Portishead Branch Line (MetroWest Phase 1)

Planning Inspectorate Reference: TR040011

9.3.1 ExA.SoCG-NSC.D1.V1 – Statement of Common Ground

Date: November 2020

Drawing
PORTISHEAD STATION CAR PARK
LAYOUT, LANDSCAPING AND NEW
BOULEVARD AND ACCESS PLAN
SHEET 2 OF 3

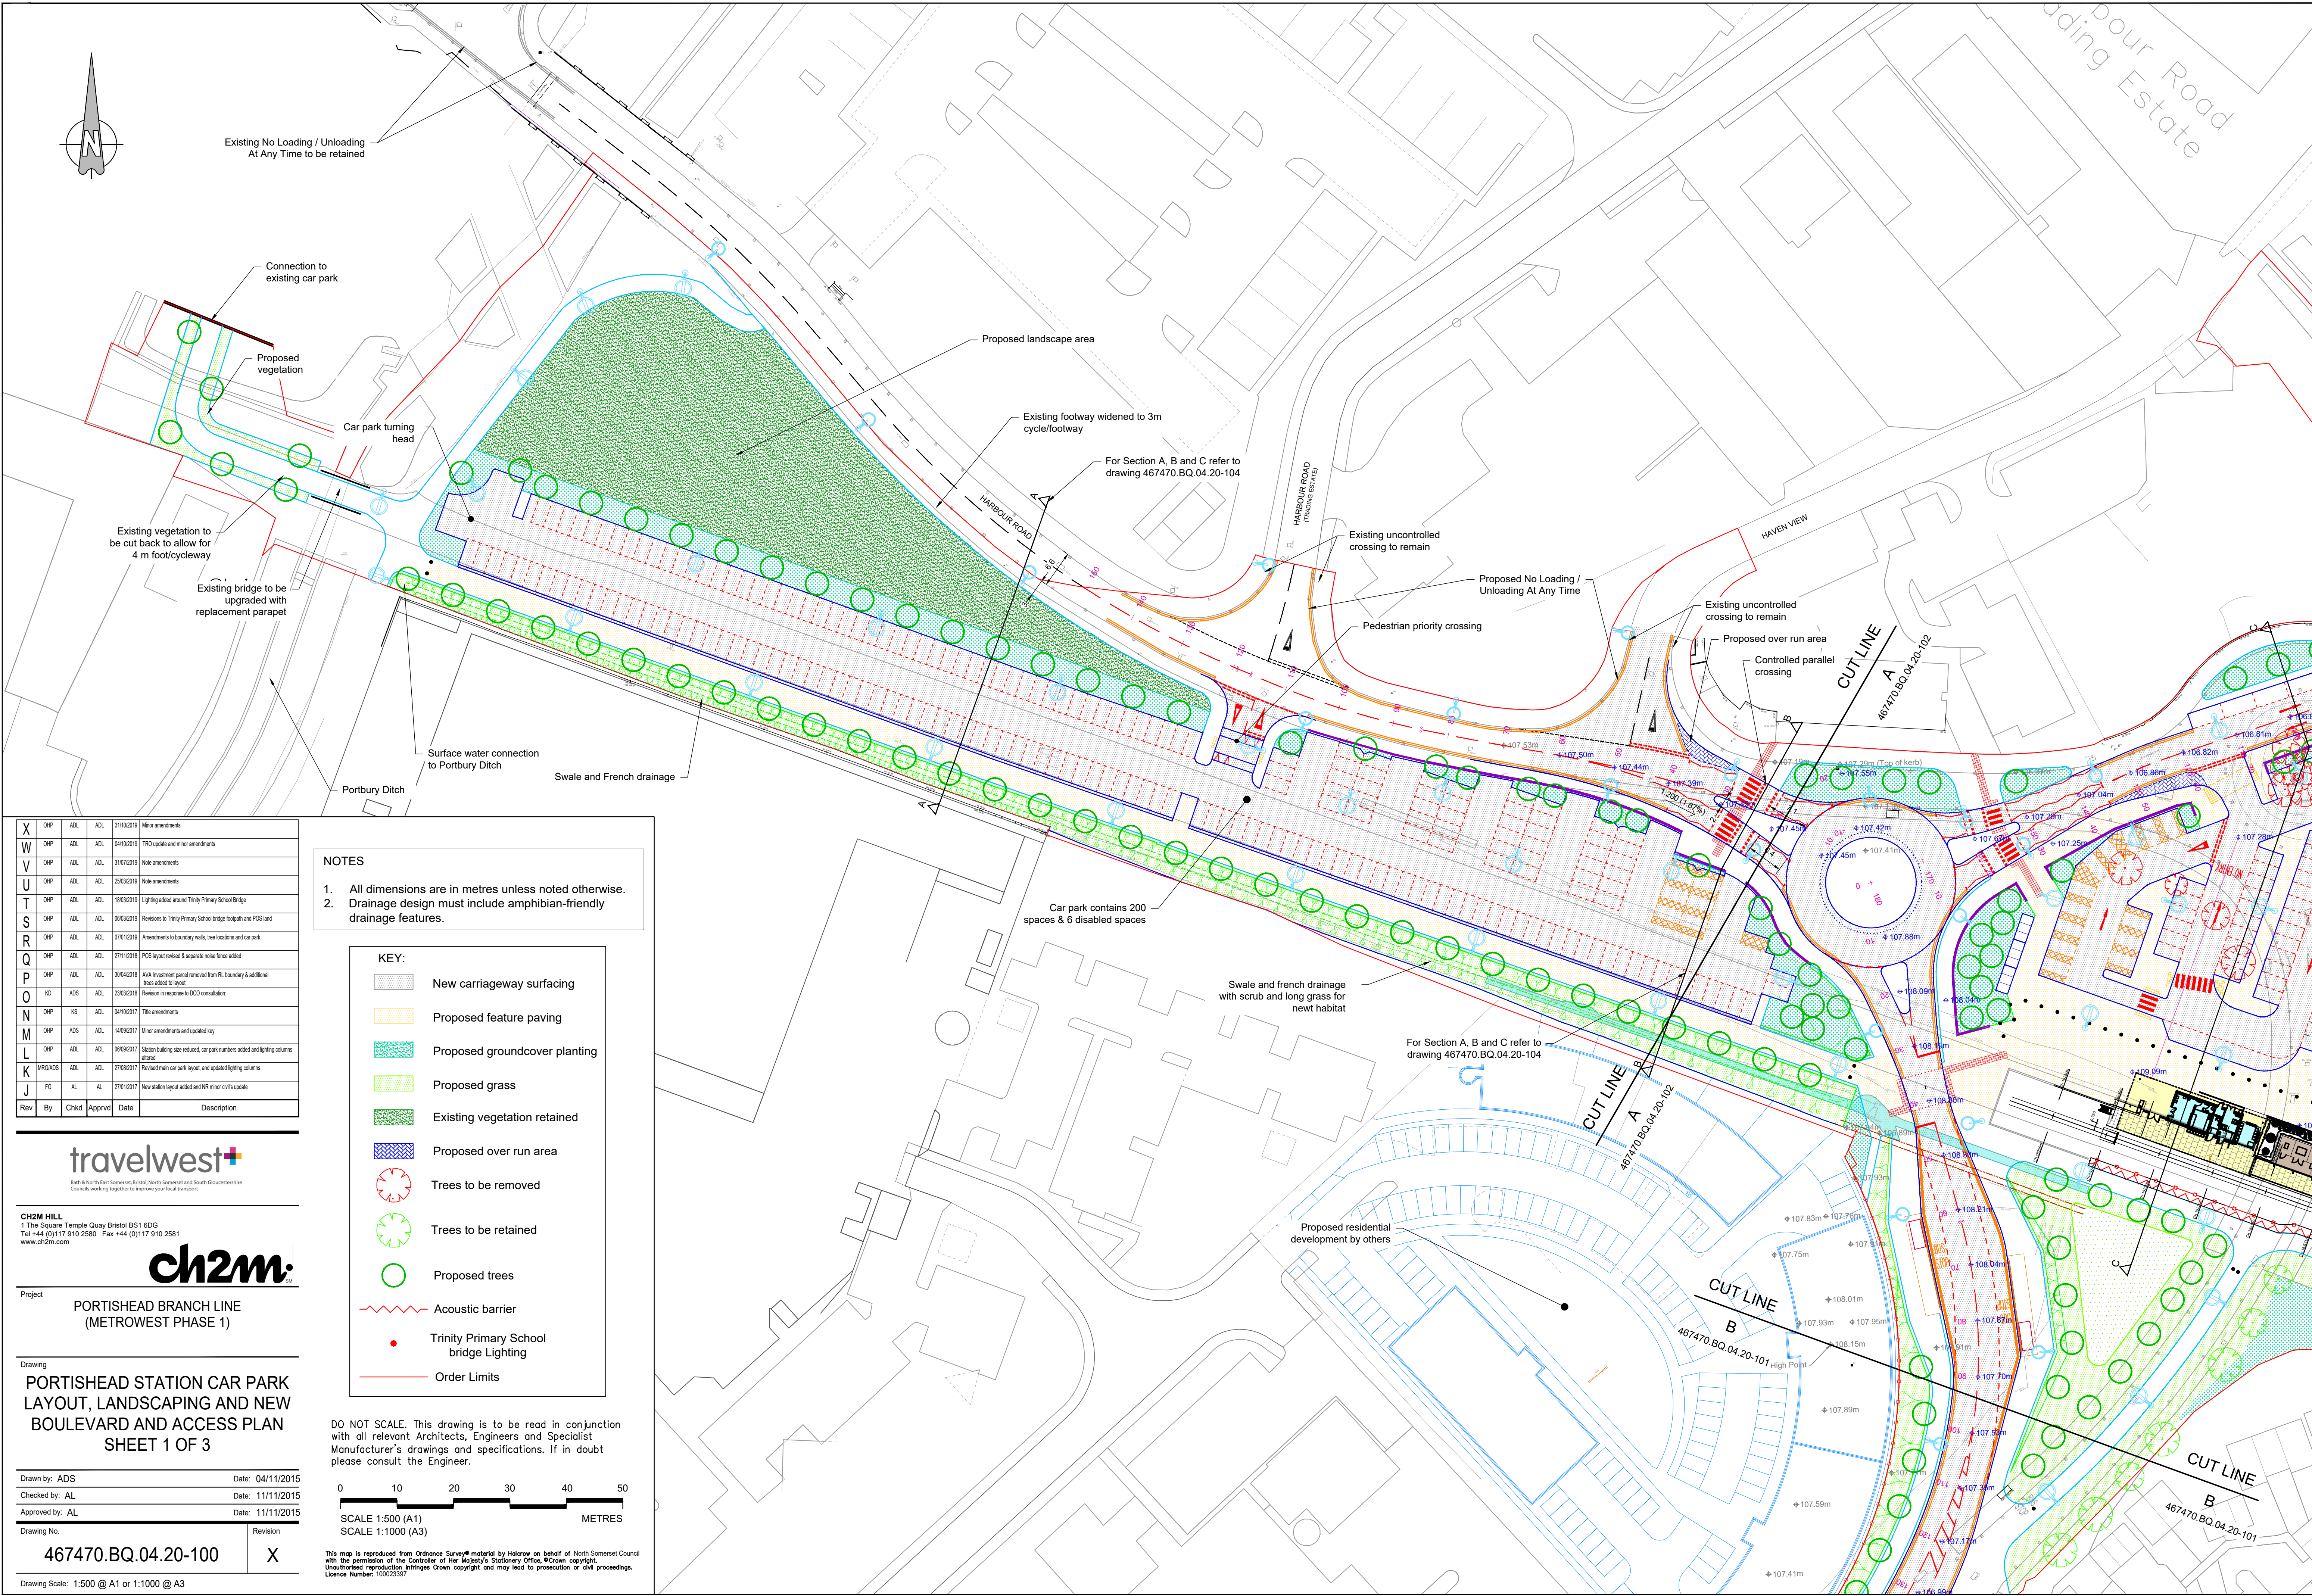
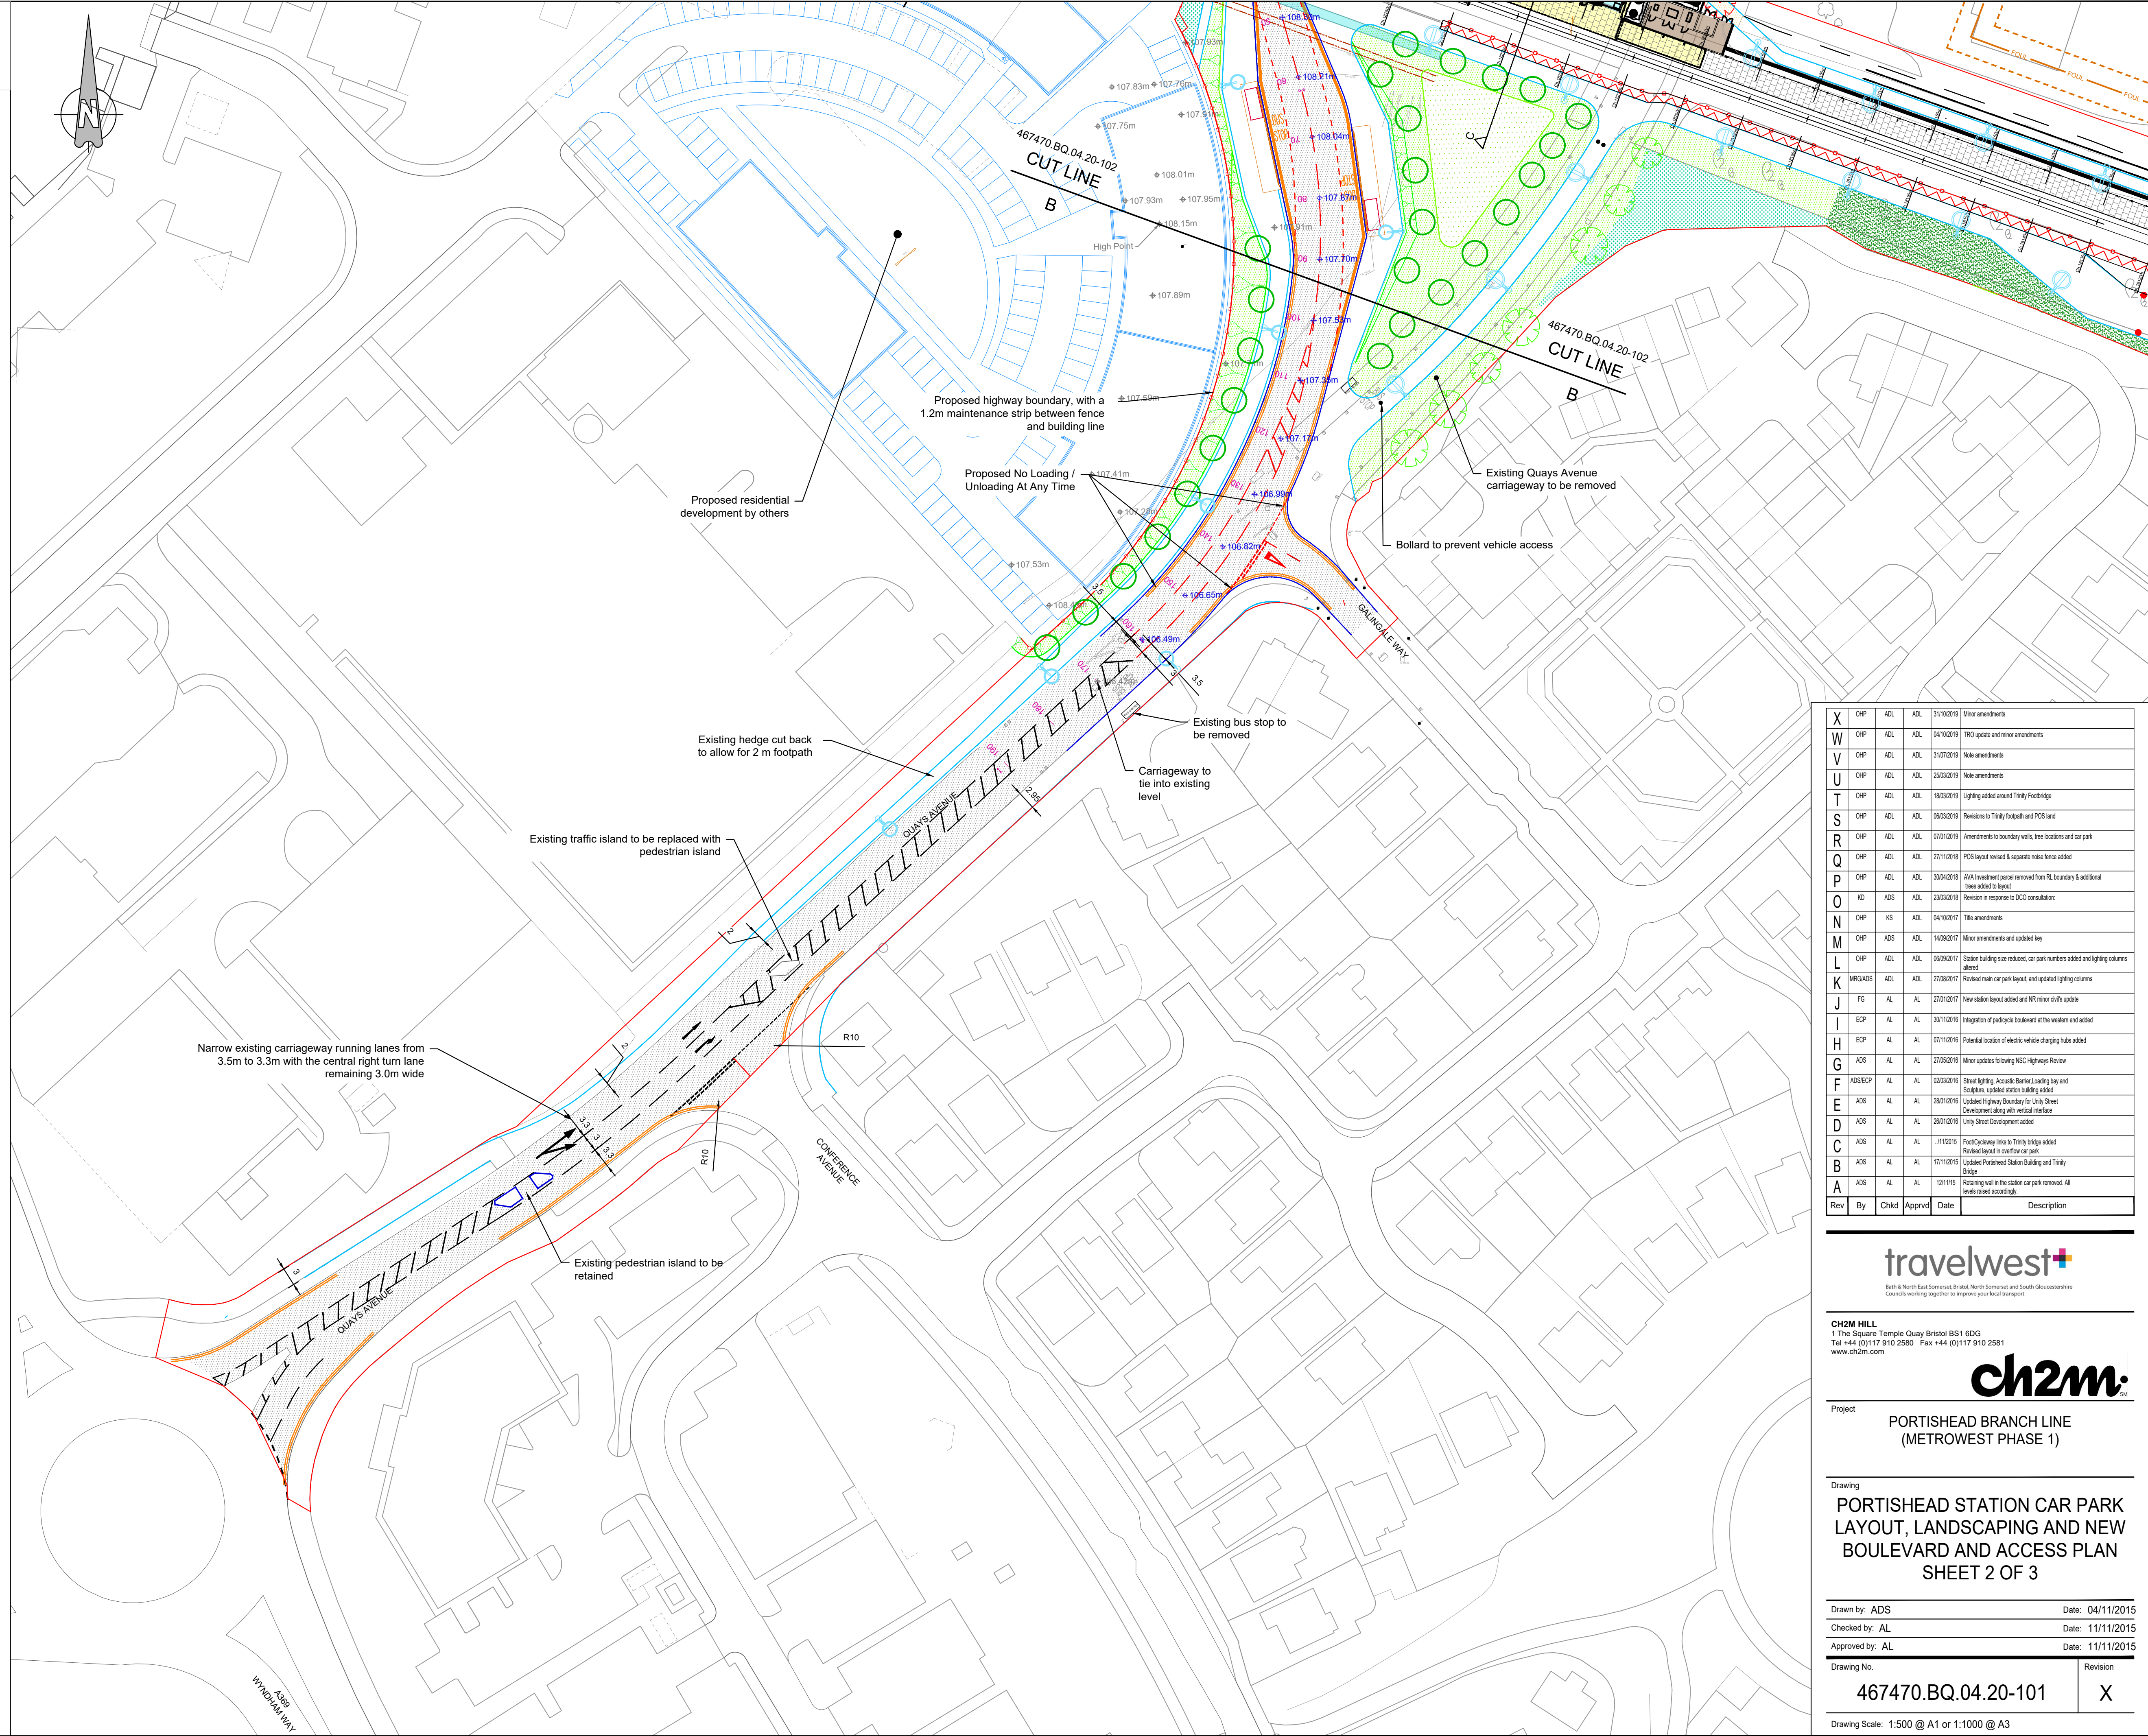
- (b) Requested further detail on how the larger car park access at the junction with Harbour Road and Papermill Gardens will operate. The proposed operation of this junction will need to be tested to demonstrate that it will operate satisfactorily;
